THE HILLS SHIRE COUNCIL

8 December 2025

Our Ref: 43/2025/PRE
Your Ref: SSD-96248991

Rouse Hill Hospital

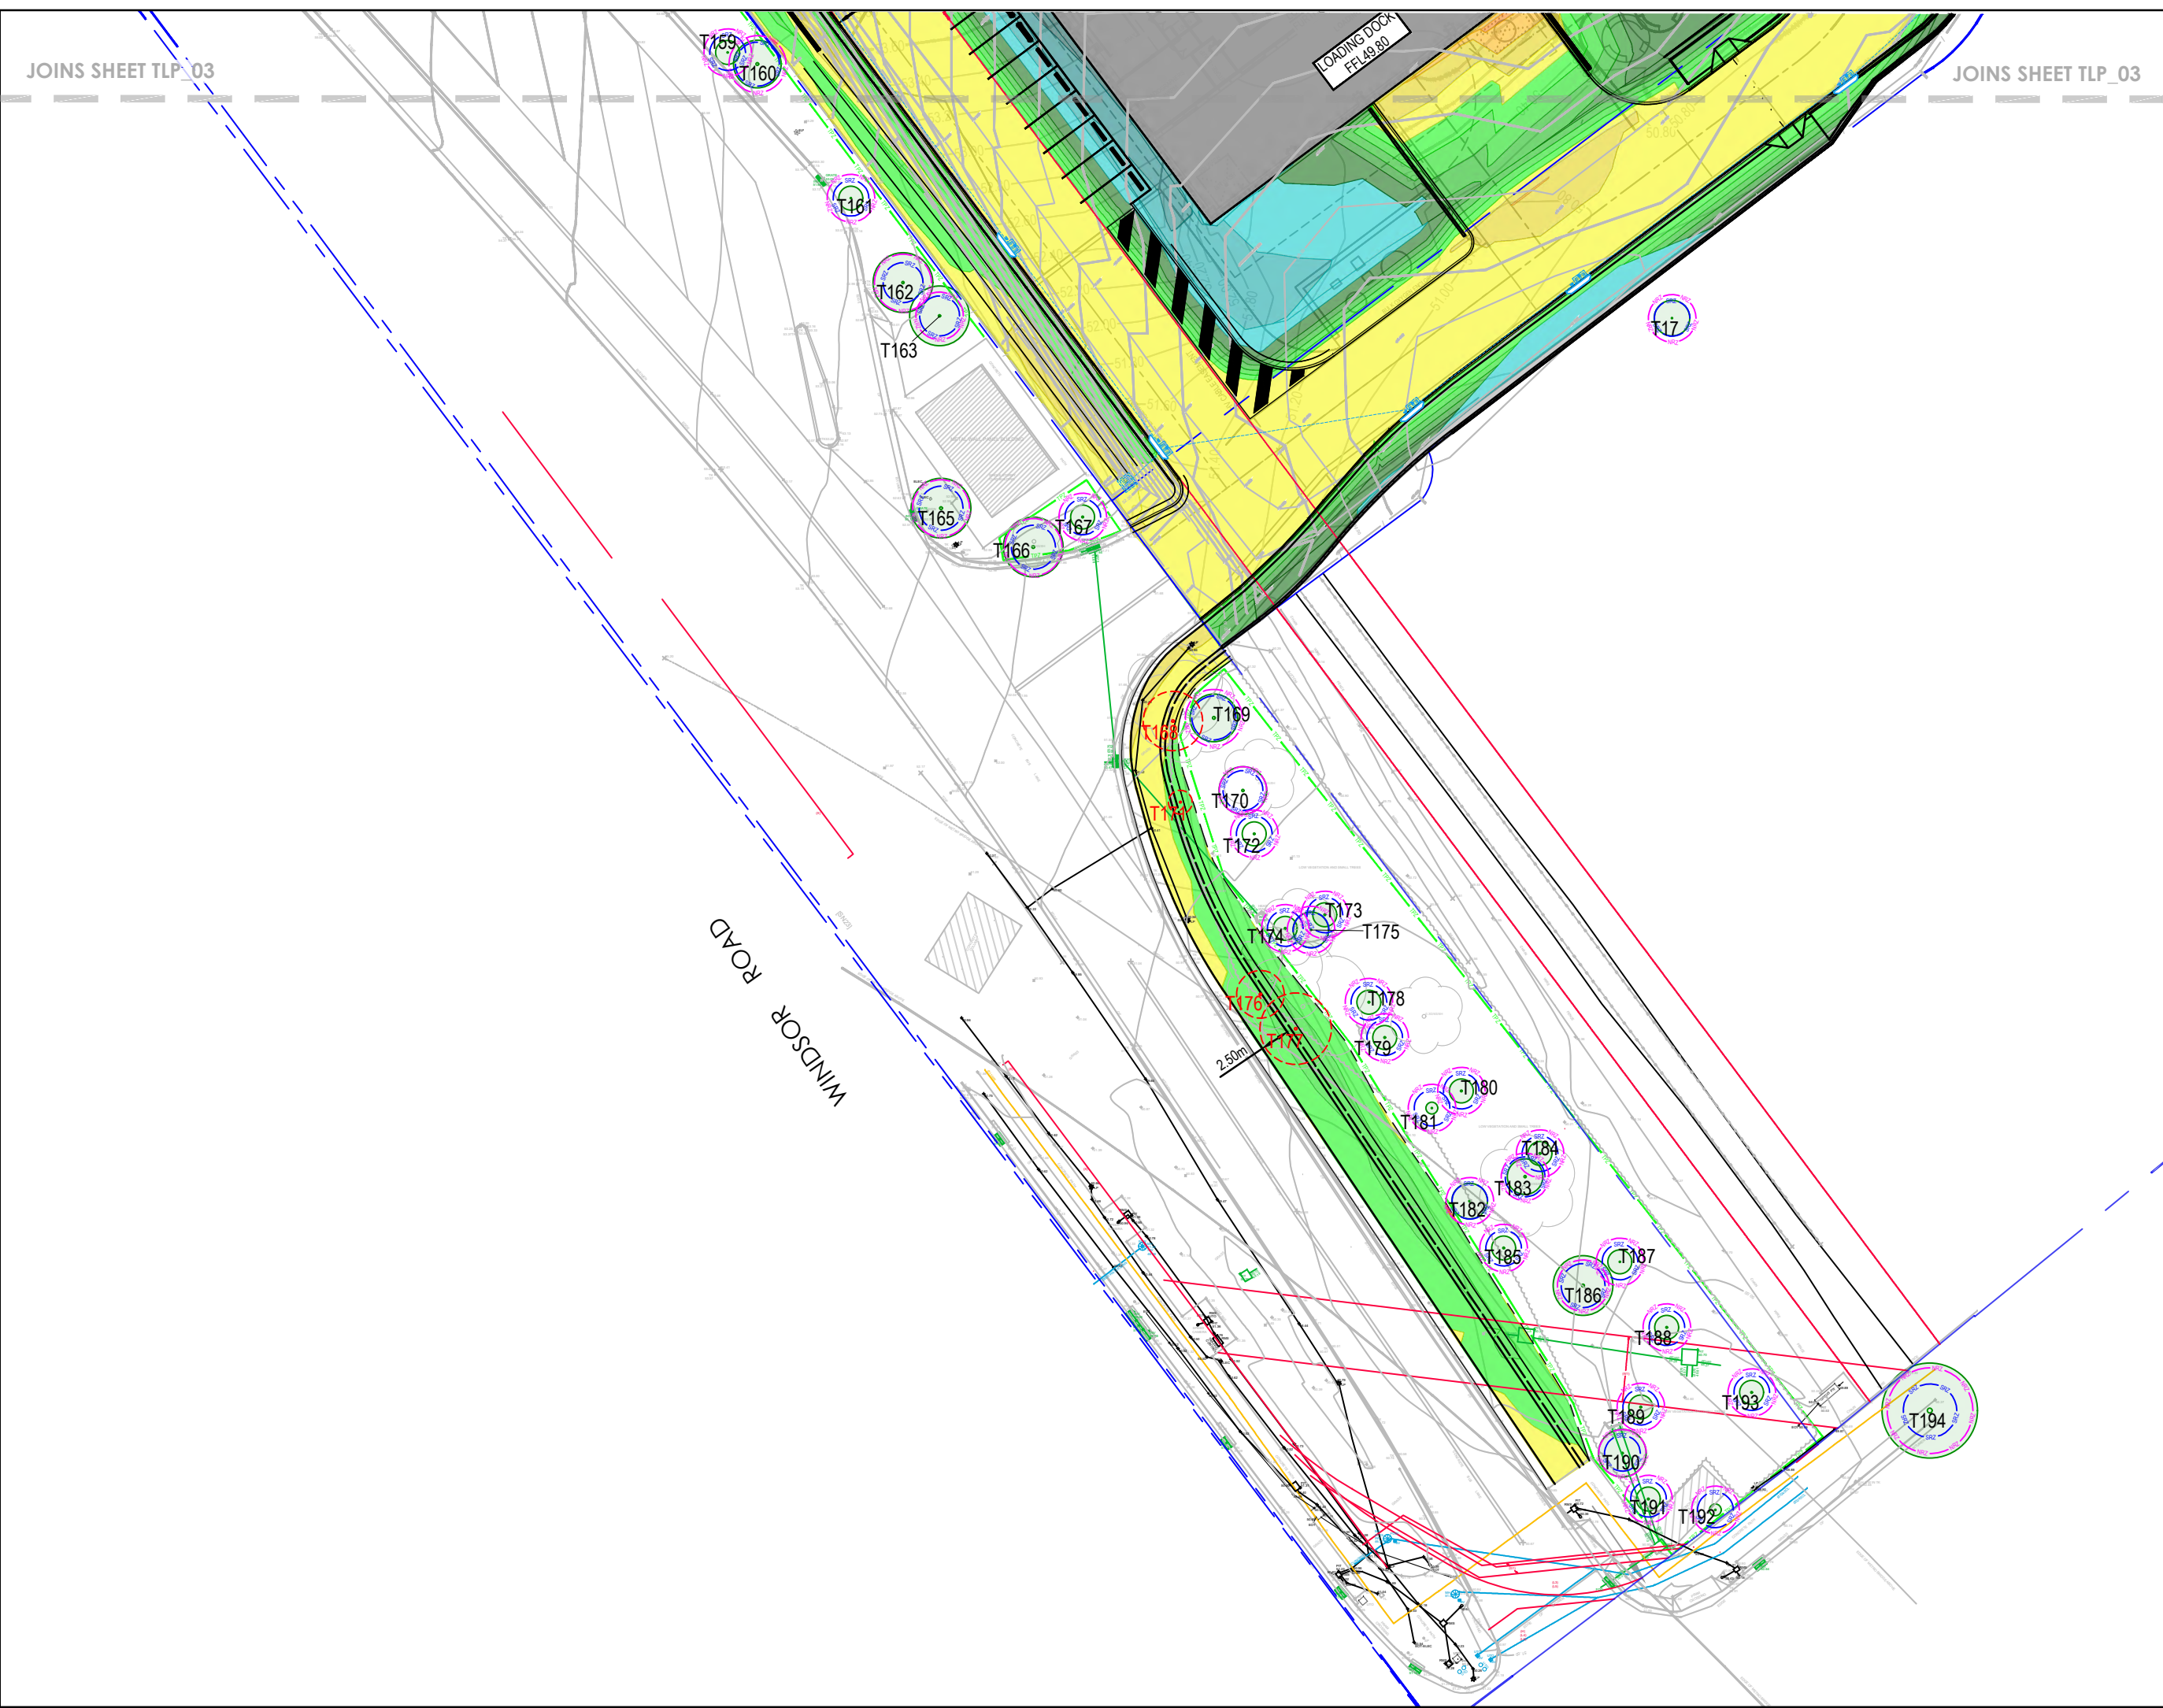
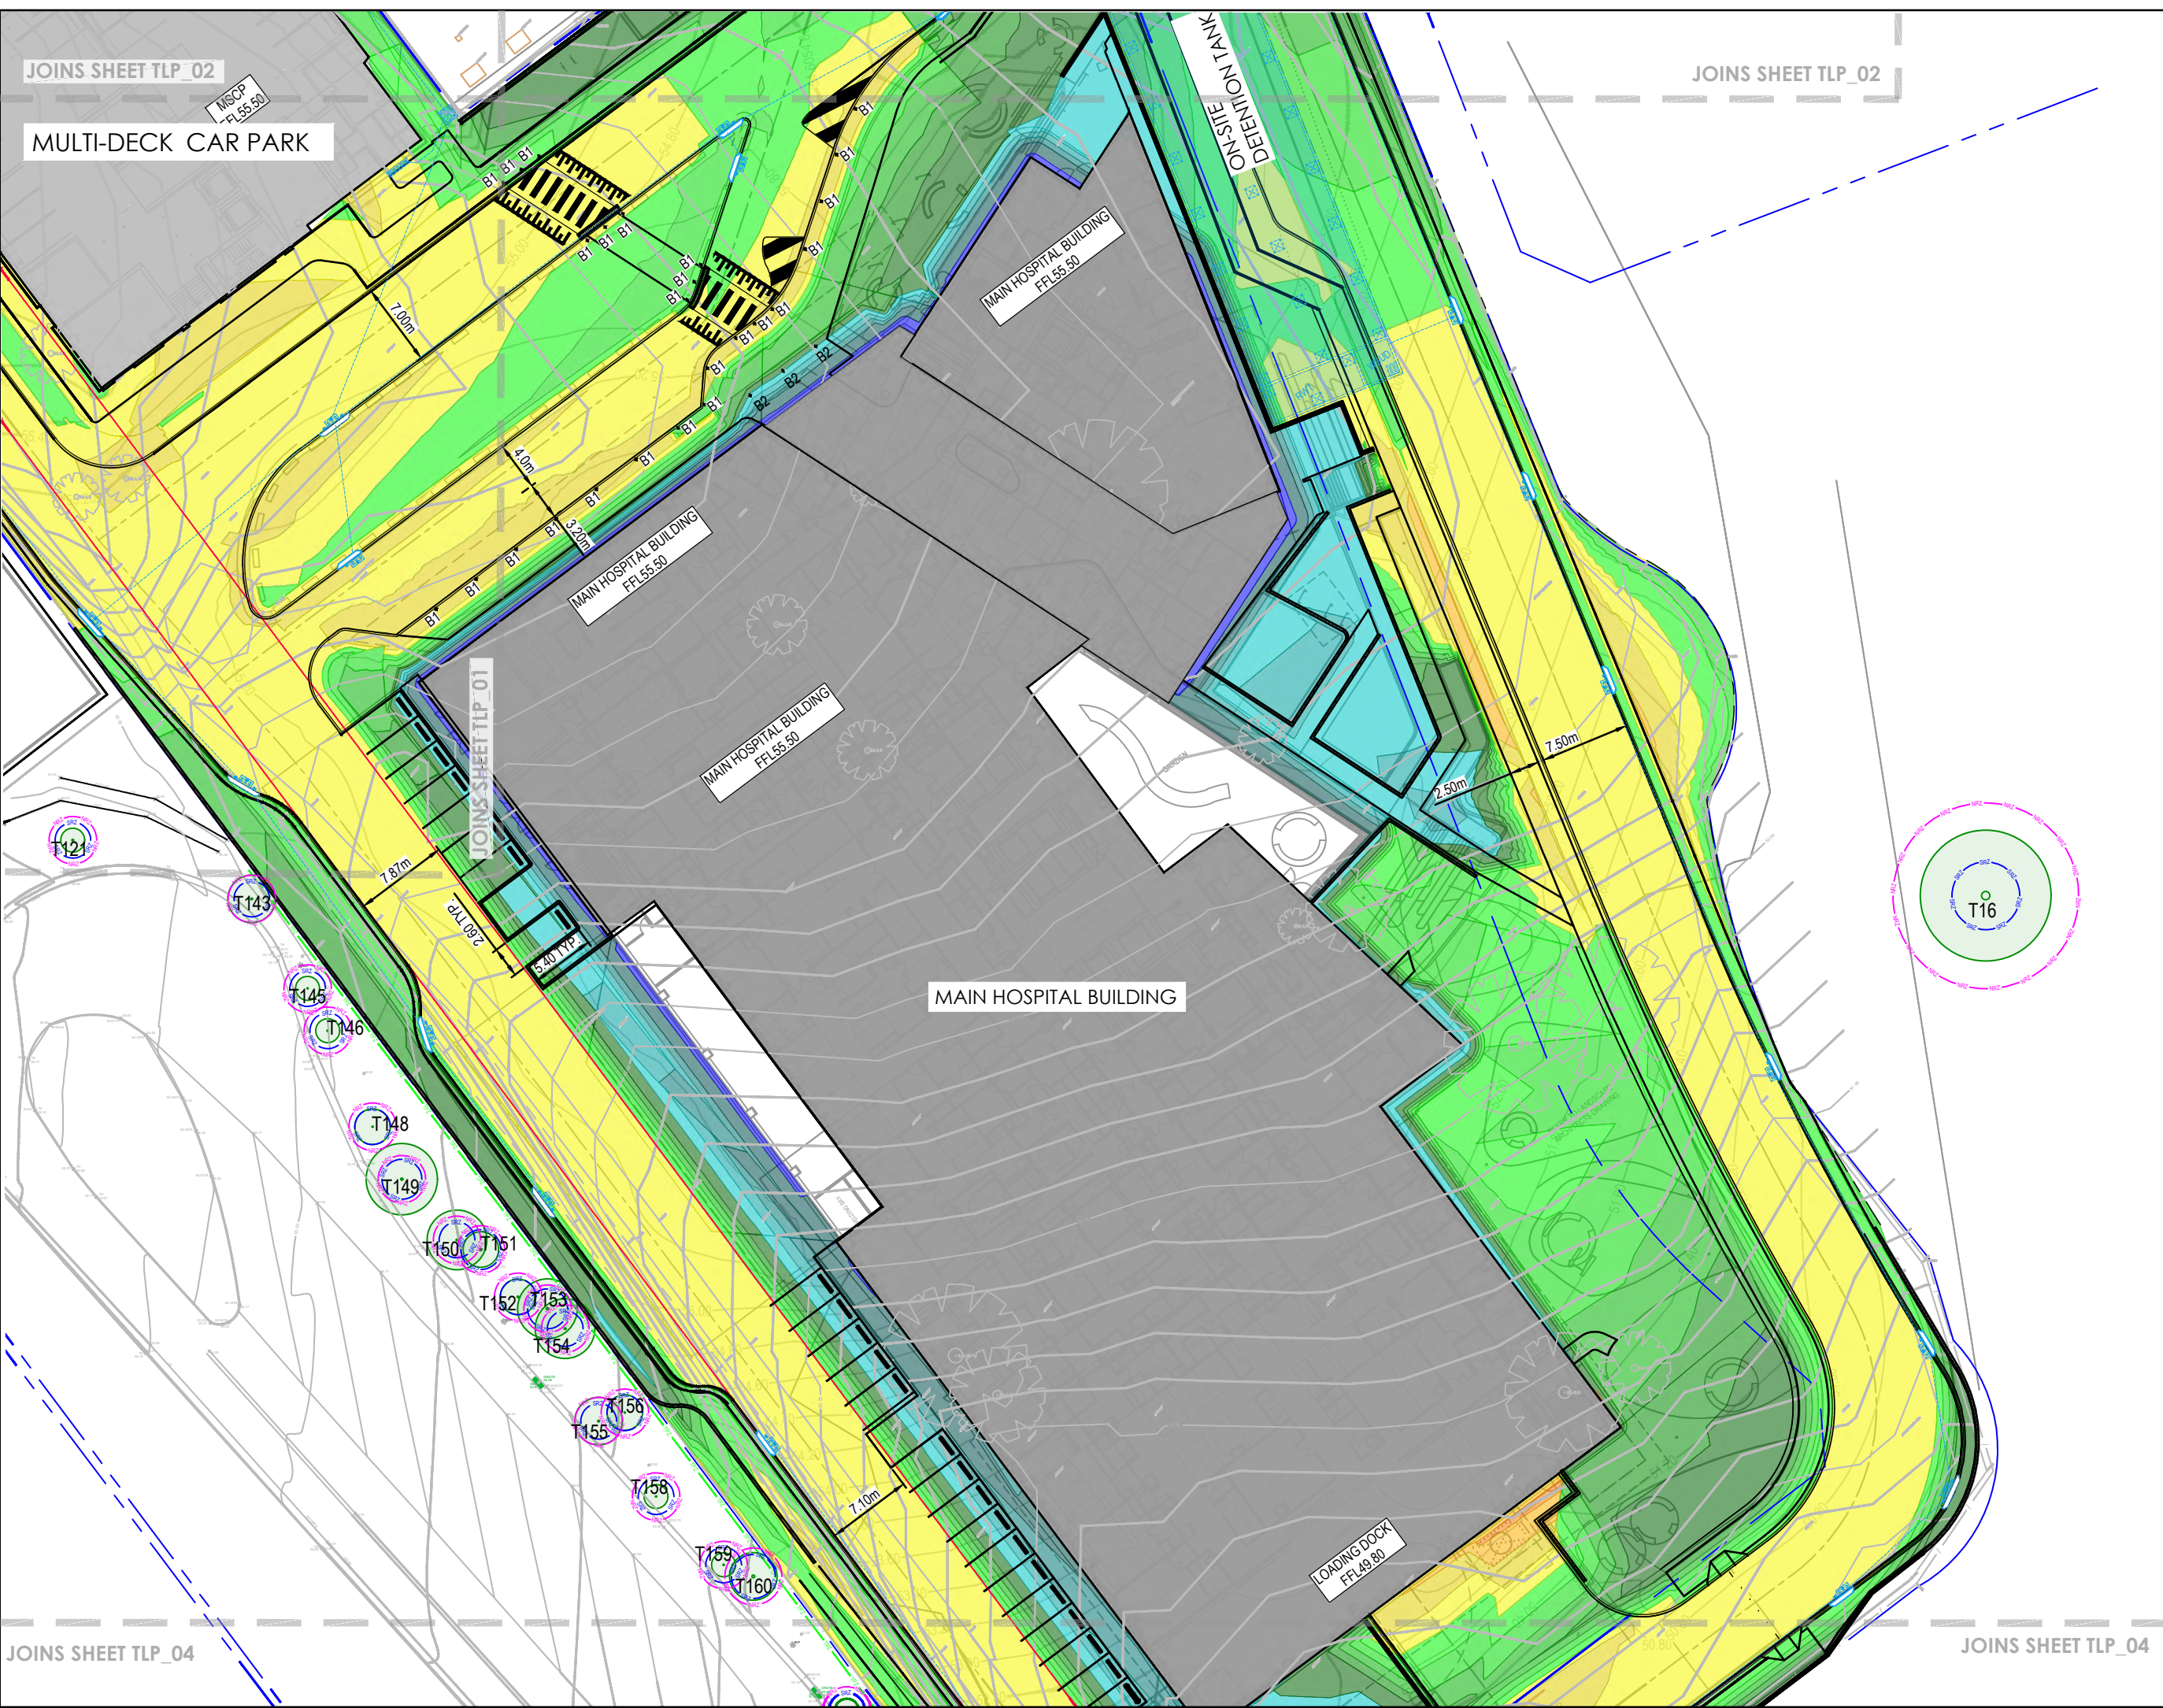
- a. Trees 43–46, identified as *Corymbia maculata*, are of high retention value and currently function as street trees along Commercial Road. Removal of these trees may be justified with measures implemented to replace them through the proposed landscape design. Replacement planting must achieve equivalent canopy contribution and comply with relevant council and AS 4970:2025 – *Protection of Trees on Development Sites* requirements.
